STAGE 1 SHEPHERDS BAY RESIDENTIAL

S75W ACCESS REVIEW

Morris-Goding Accessibility Consulting

30th October 2013

LG-04
GF-04
1-04

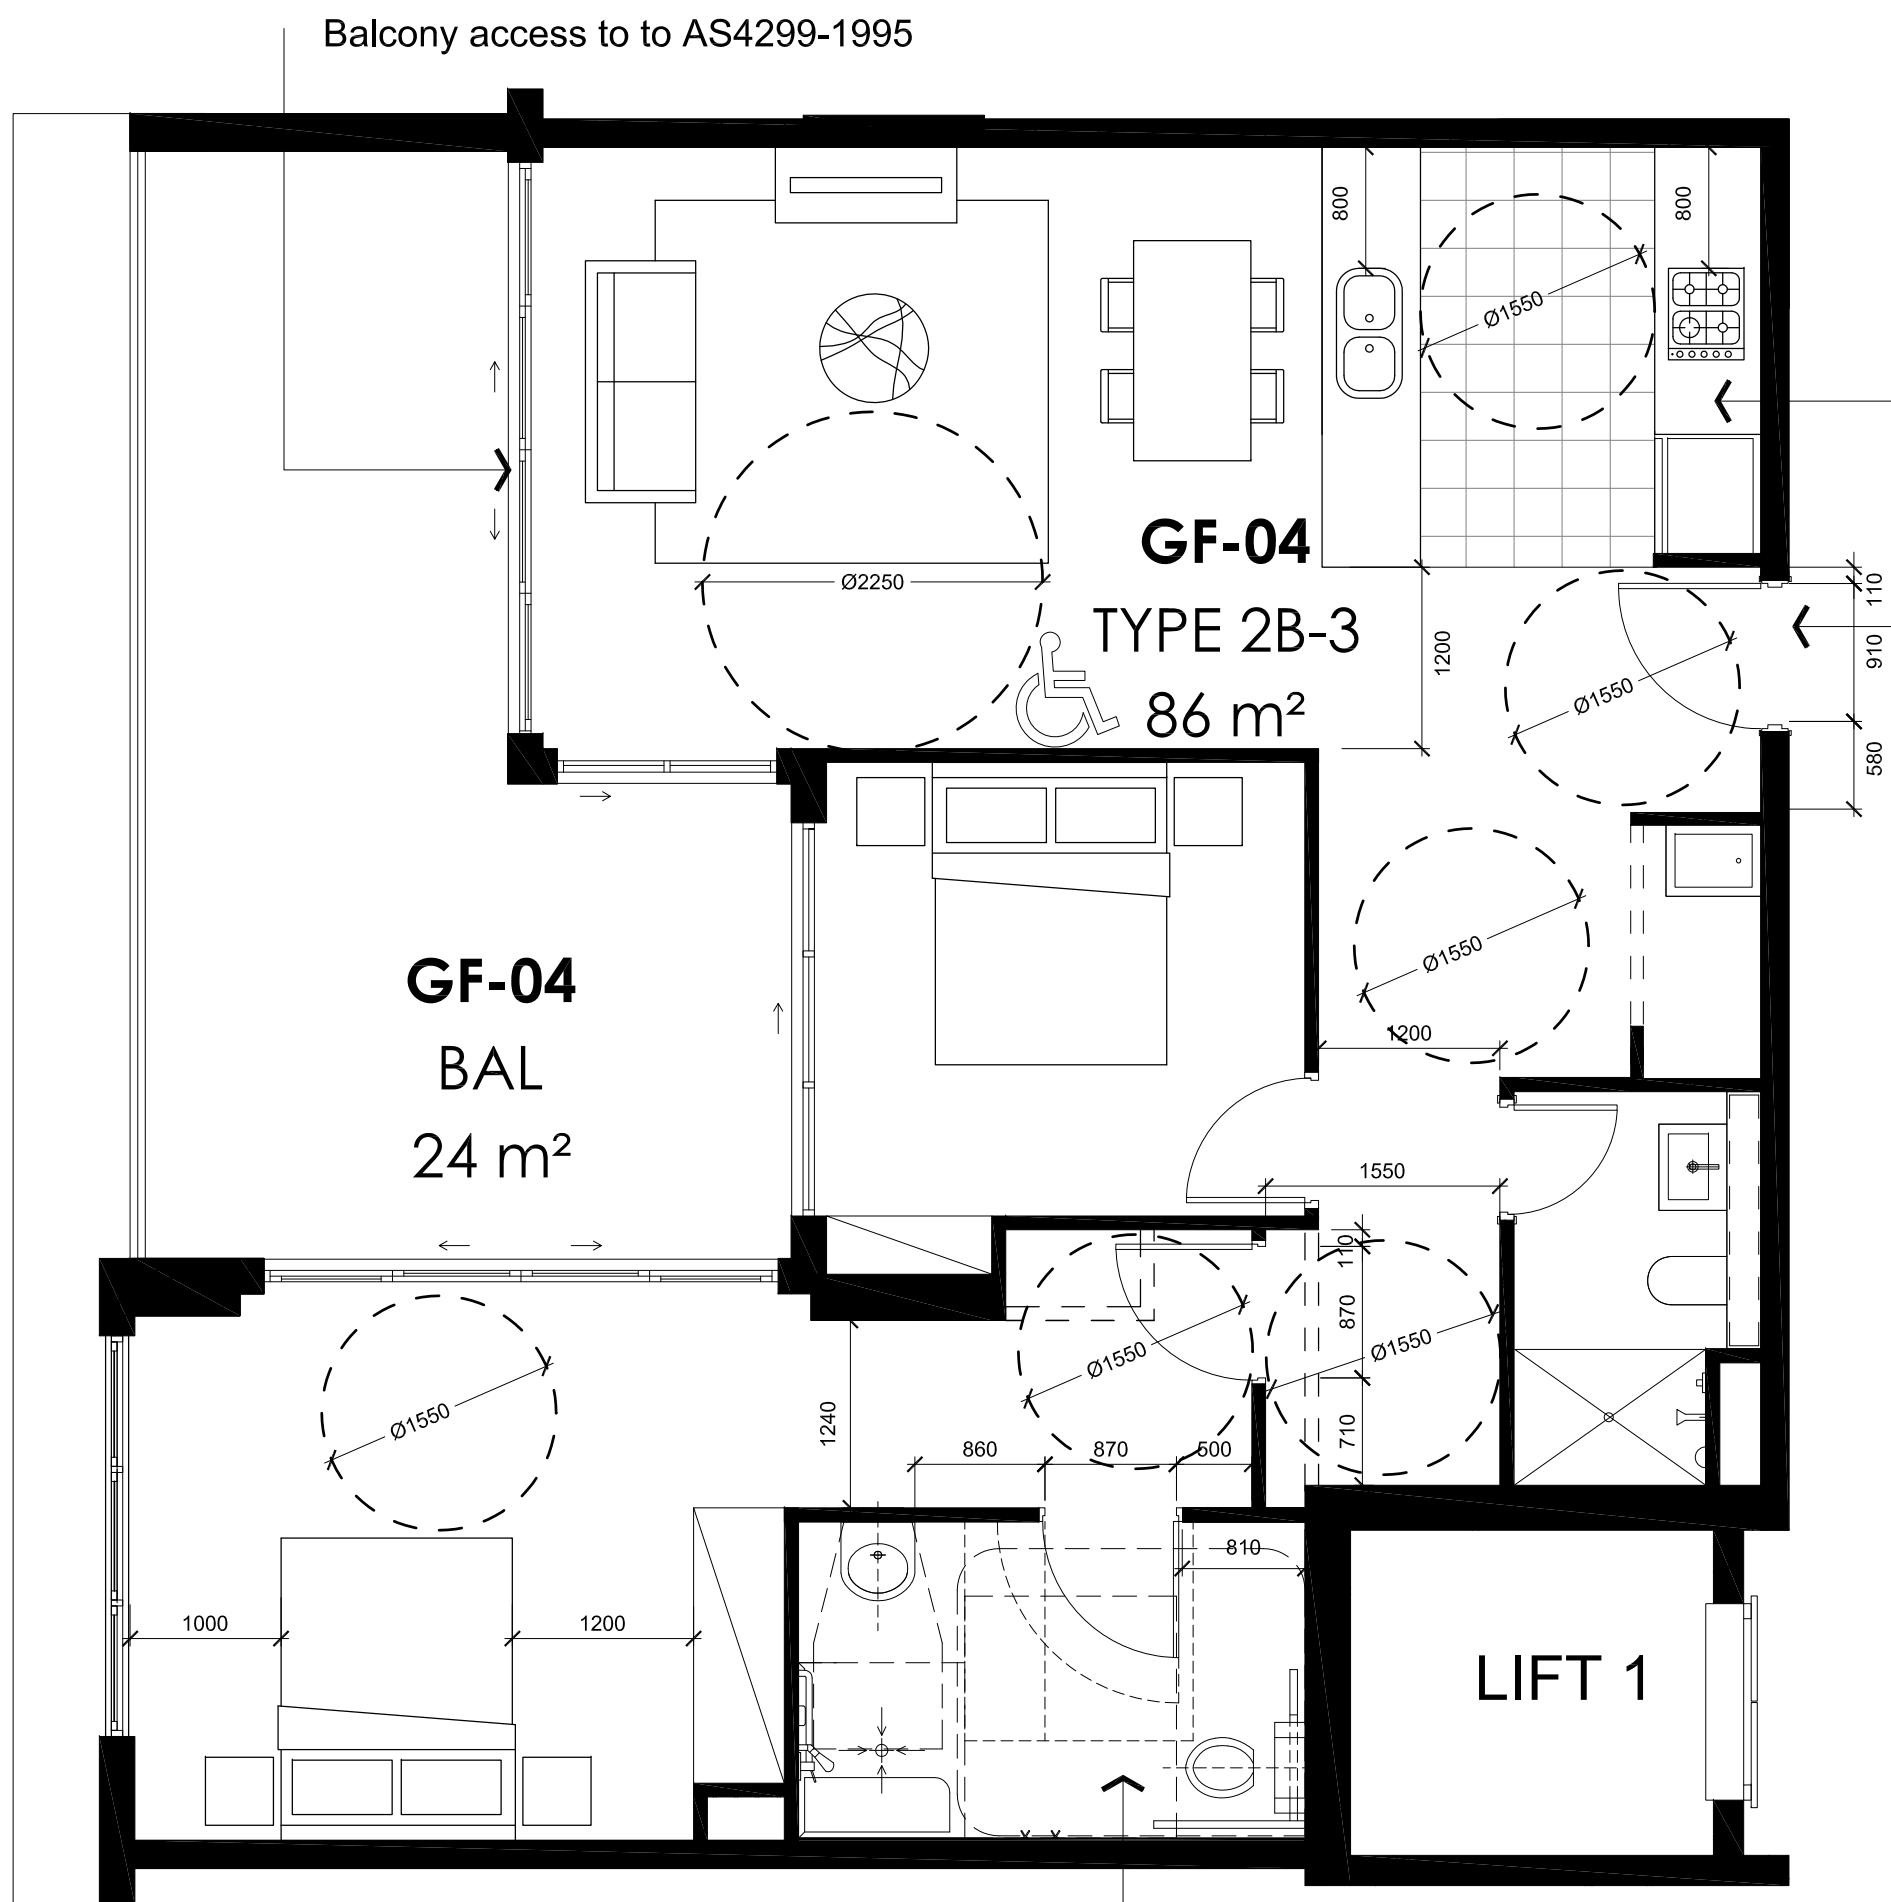
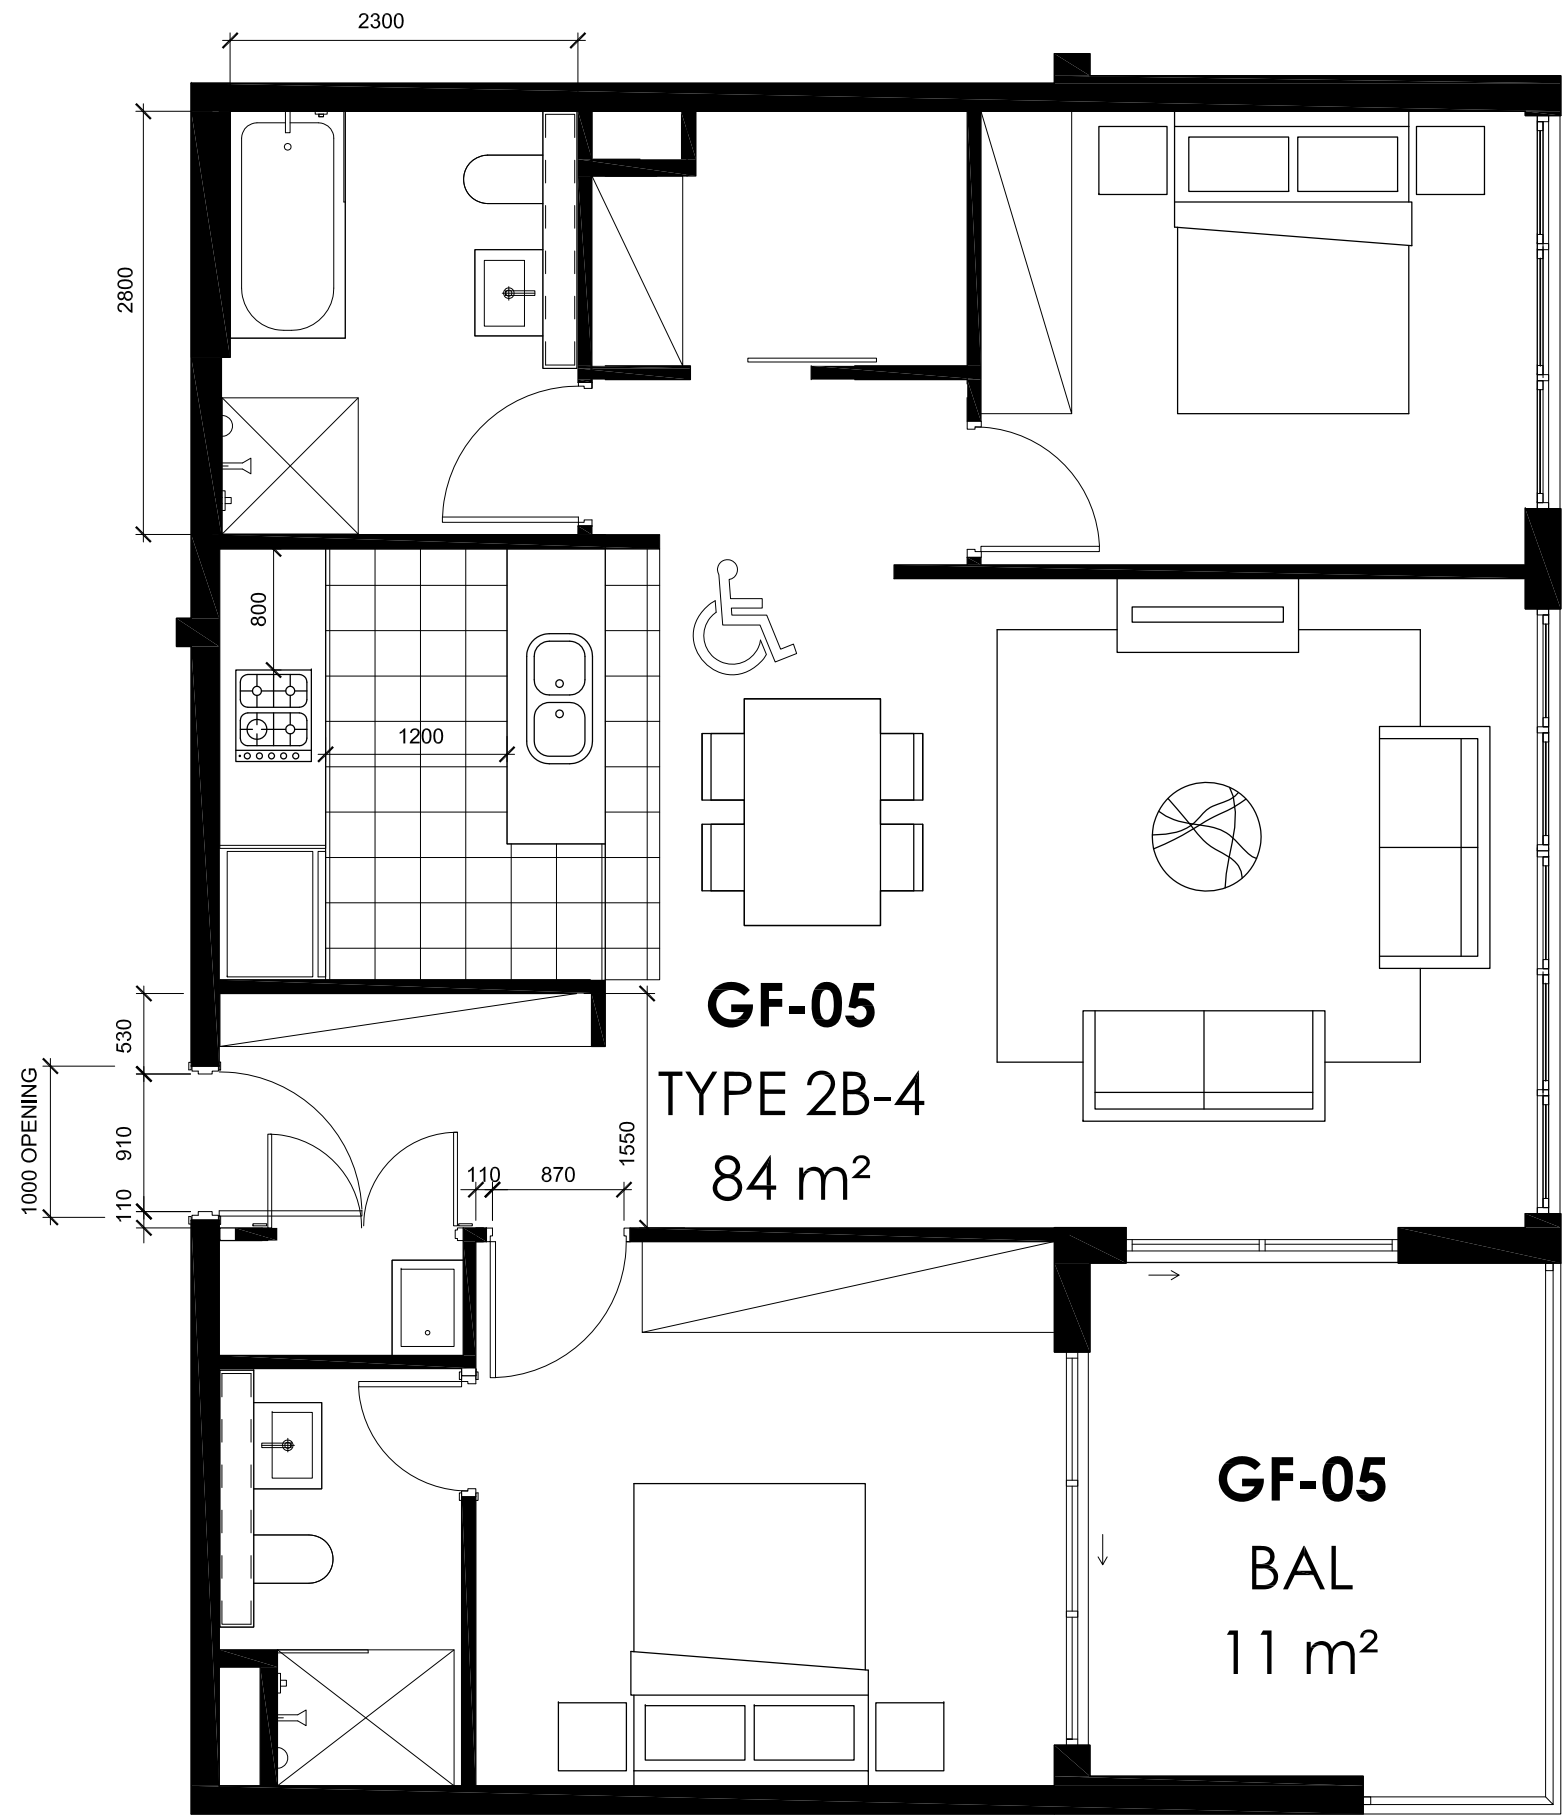
- (i) Provide appropriate capped off services for electrical and plumbing within the accessible en-suite at pre-adaptation stage. This is to be reviewed at design development stage.
